Unit:		House number:	7	House suffix:	
House name:					
Address 1:	THE CRESCENT				
Address 2:	FELHAM				
Address 3:					
Town:	BOGNOR REGIS				
County:	WEST SUSSEX				
Postcode (optional):					
Description of location or a grid reference. (must be completed if postcode is not known):					
Easting:		Northings:			
Description:

ERECTION OF 1 NO 4 BEDROOM HOUSE

FR / 206 / 08

8. Non-Material Amendment(s) Sought

Project Proposed plans and elevations	Sheet
Date 12th November 2011	1
Scale 1 : 100 & 1 : 50

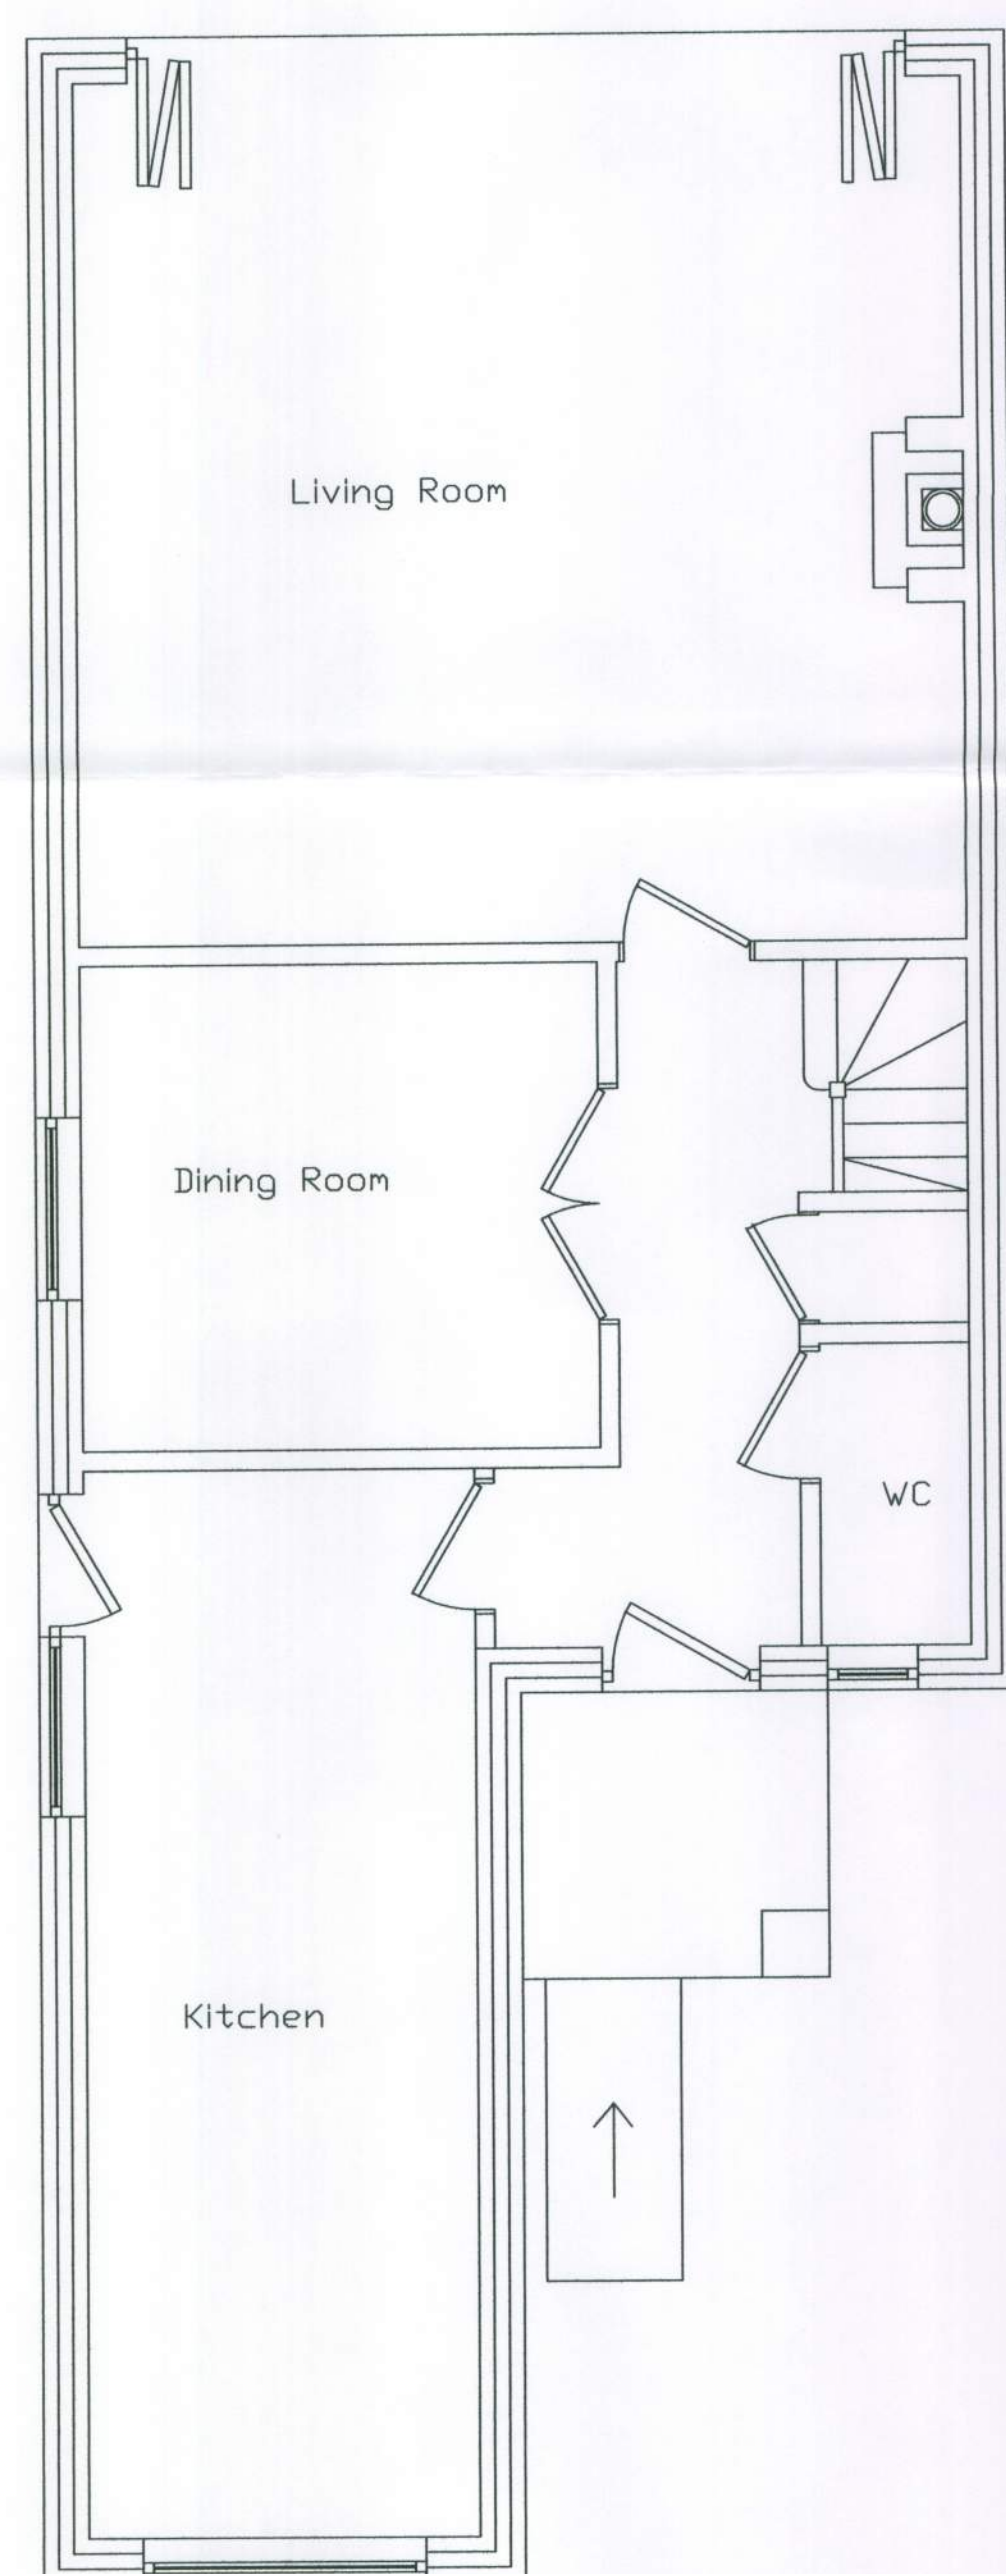
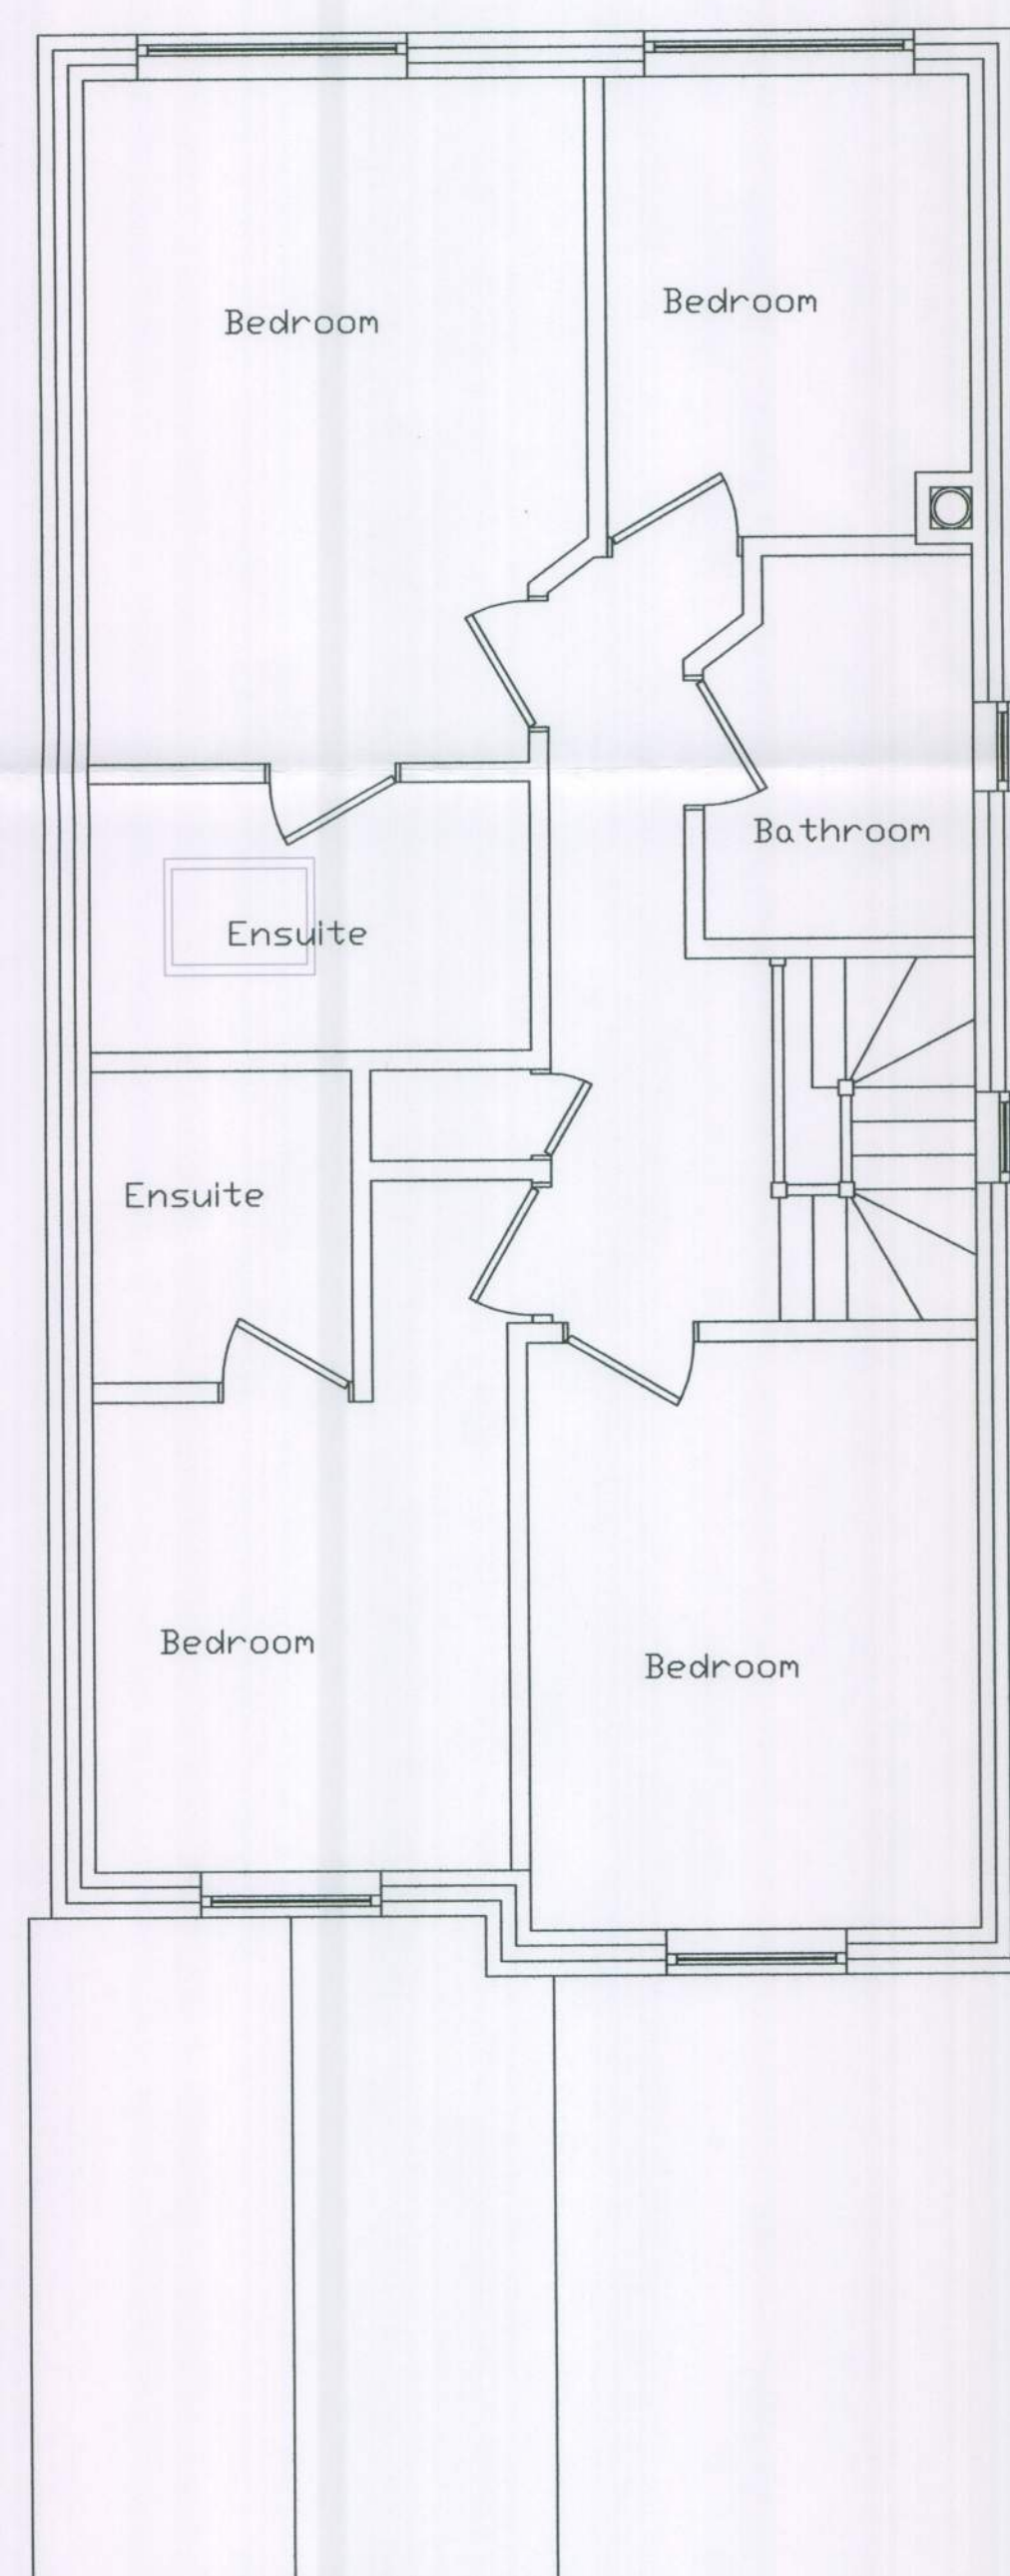
REMOVAL OF REAR BALCONY

CHANGES TO WINDOWS & DOORS

INTERNAL LAYOUT CHANGE

CHANGES TO PARKING ARRANGEMENTS

(THE NEW CARPORT & CYCLE STORE I BELIEVE ARE PERMITTED DEVELOPMENT)

TO IMPROVE THE INTERNAL LAYOUT AND OVERALL USE OF THE LAND.
